## **DEPARTMENT OF PUBLIC WORKS**

TO: All Staff  
FROM: Public Works Plan Review Team  
DATE: October 27, 2021  
SUBJECT: LPF-21-00006 Forest Ridge II Third Review

DWN BY	DATE	JOB NO.
T.S.	09/2021	18069
CHKD BY	SCALE	SHEET
M.K.K./D.L.P.	1" = 500'	3 OF 7

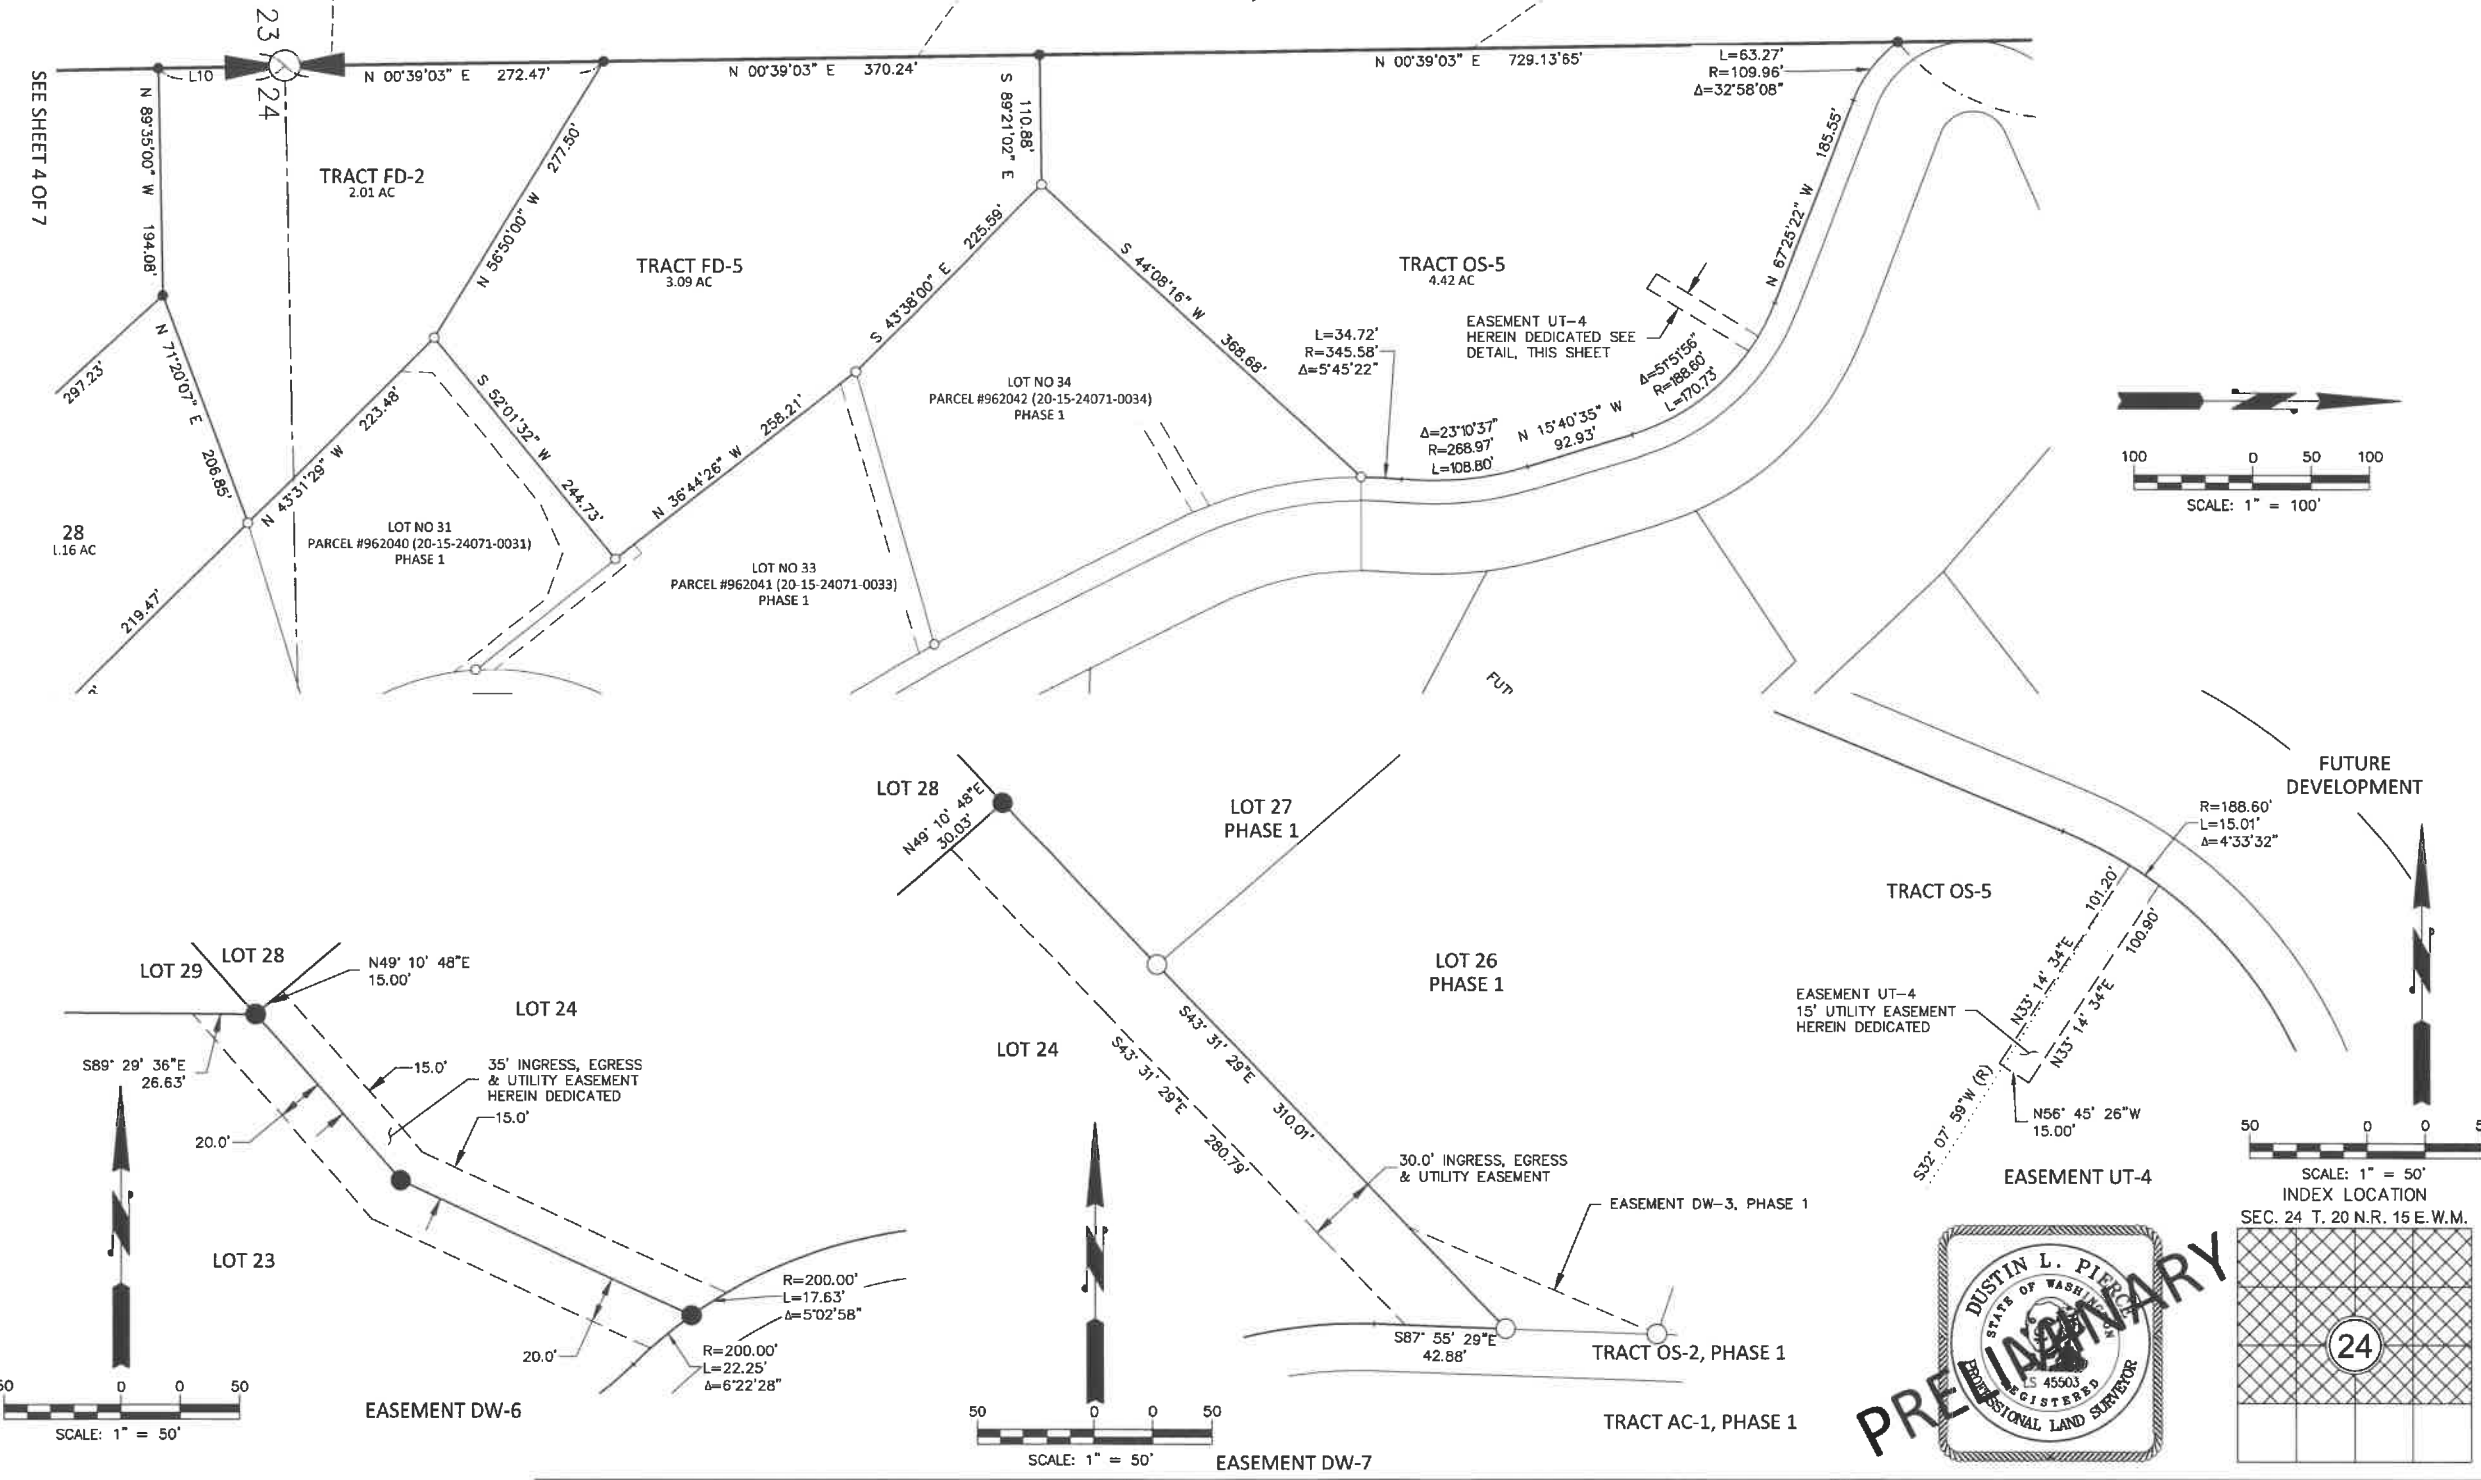
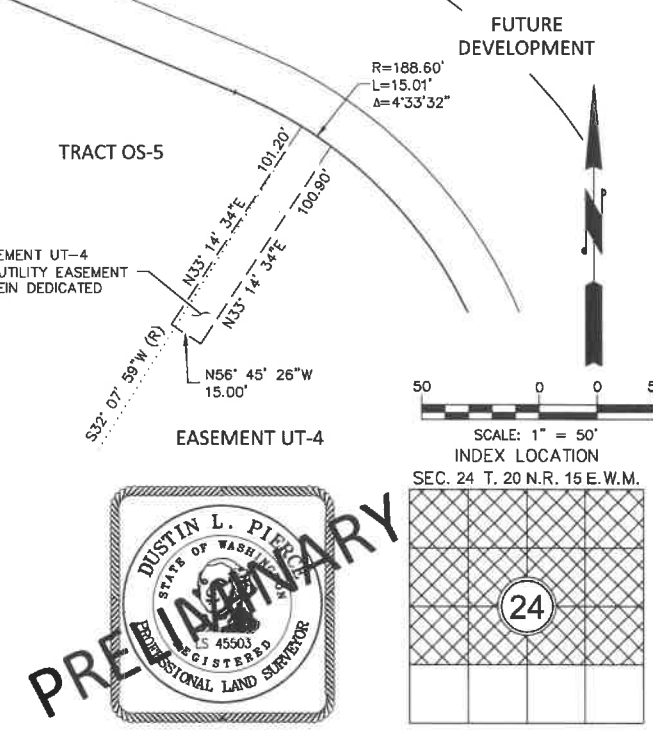
1. The area for Tract FD-4A does not match the closure report.

DWN BY	DATE	JOB NO.
T.S.	09/2021	18069
CHKD BY	SCALE	SHEET
M.K.K./D.L.P.	1" = 100'	7 OF 7

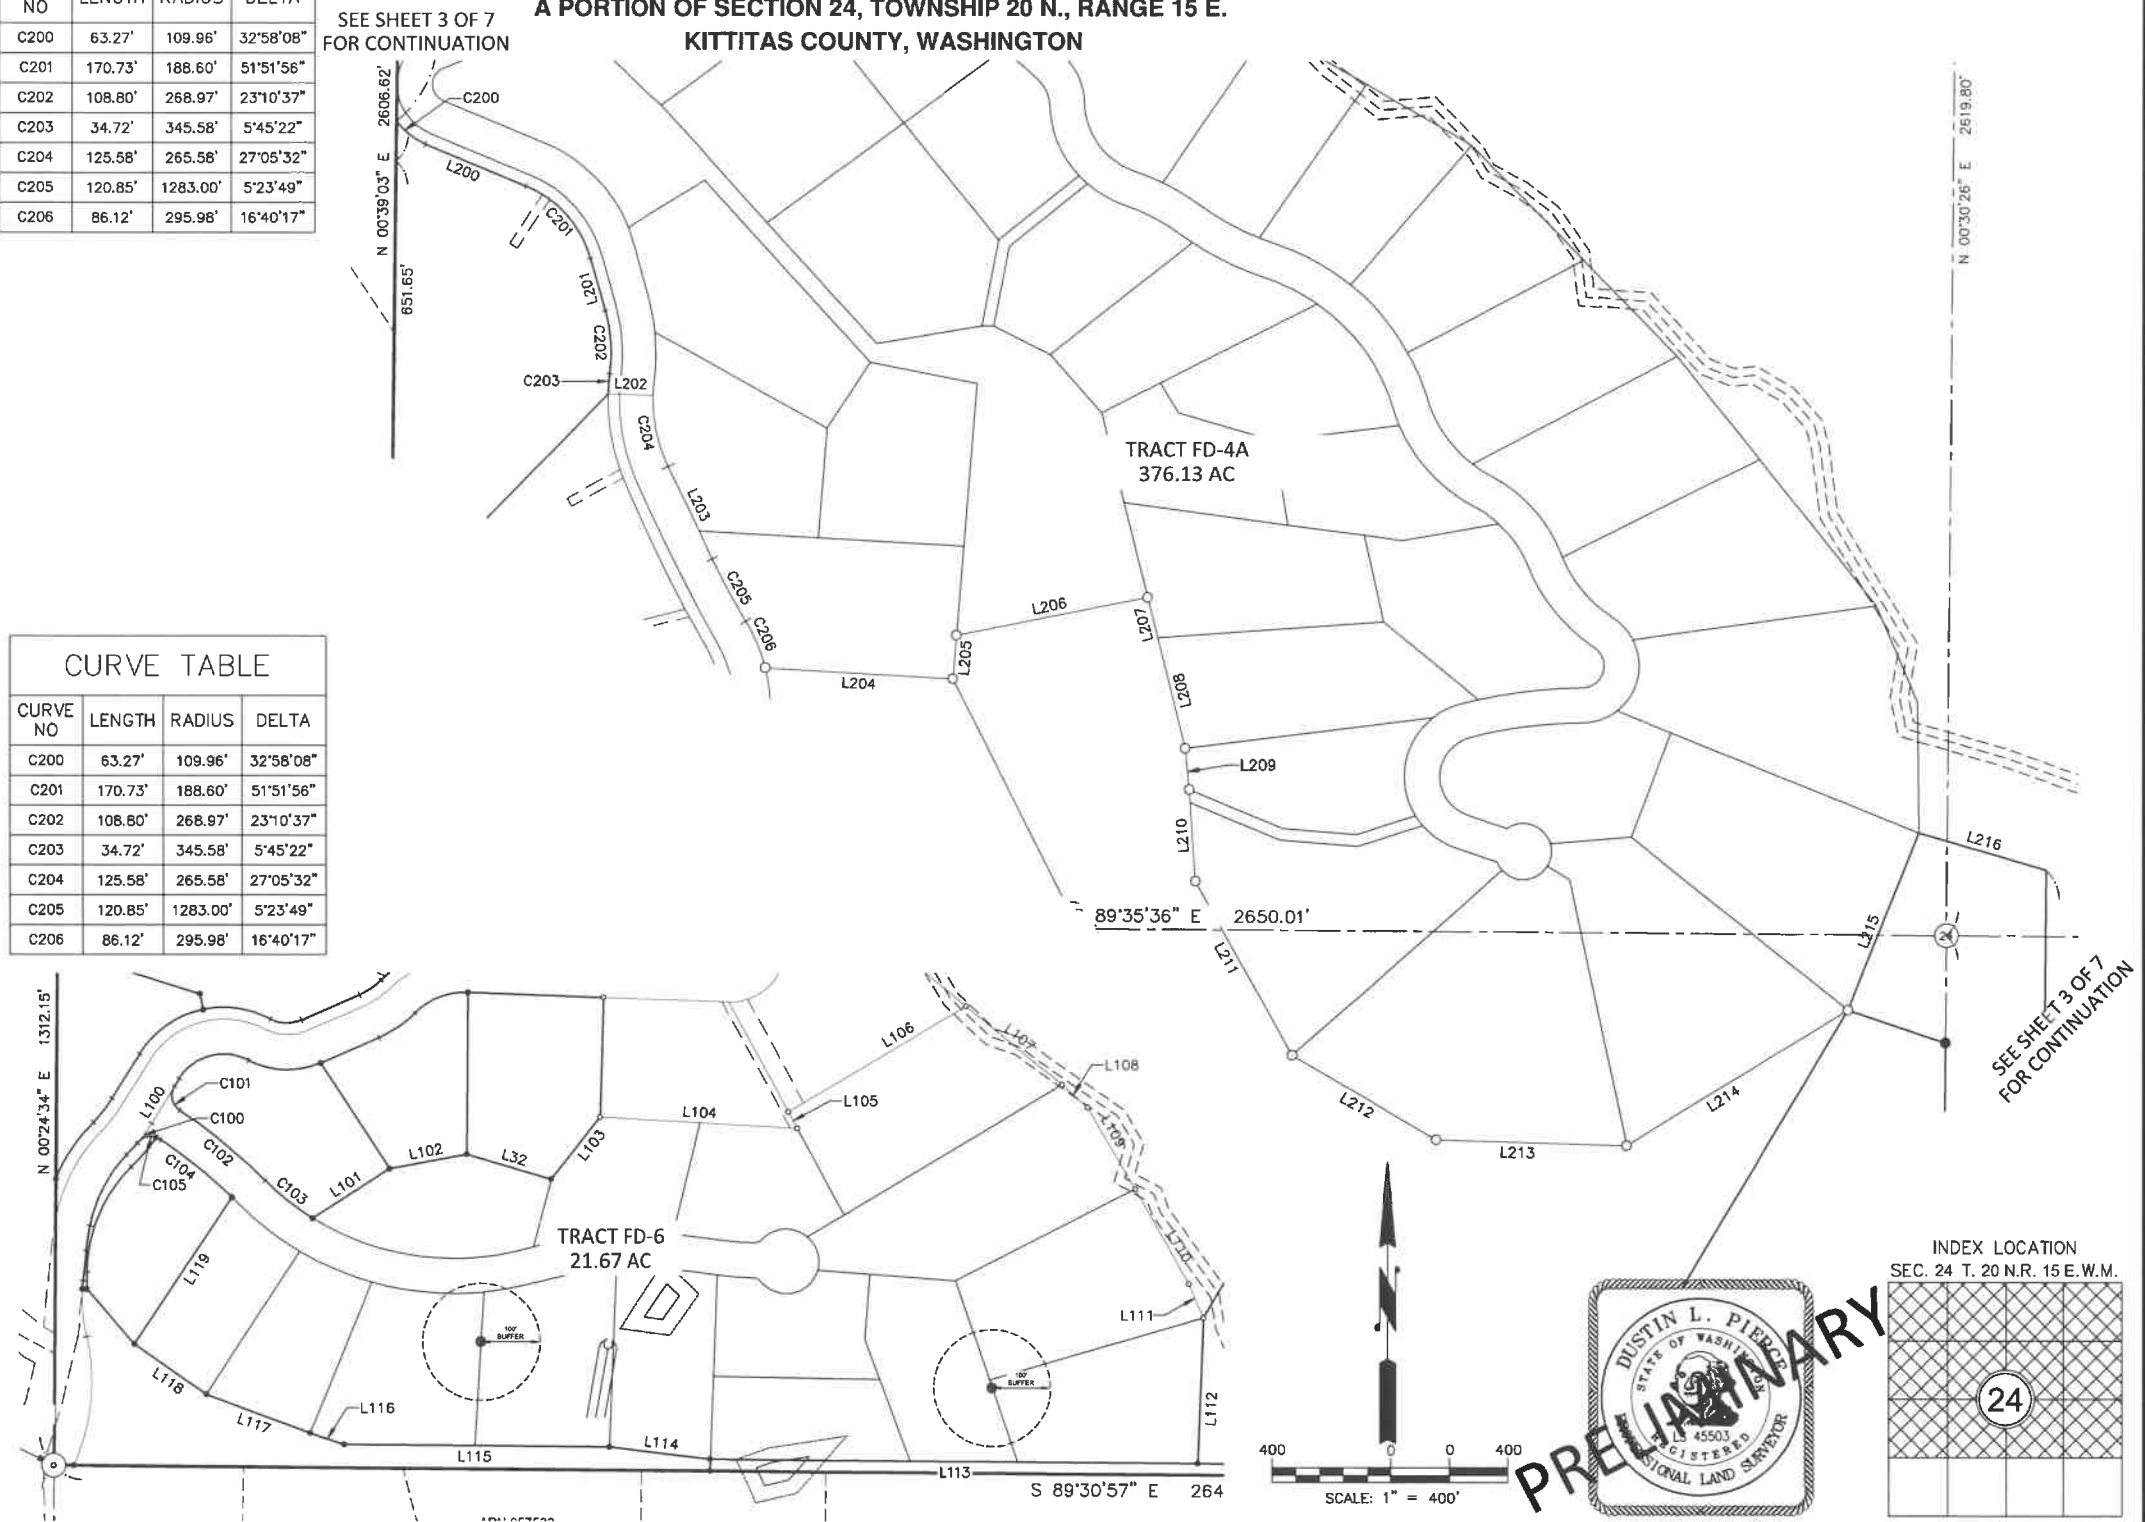
1. The area for Tract FD-4A does not match the closure report.
2. The Line/Curve Tag Labels L105, L116, and C105 do not match the closure report. Curve C105 should match C9 on sheet 4.
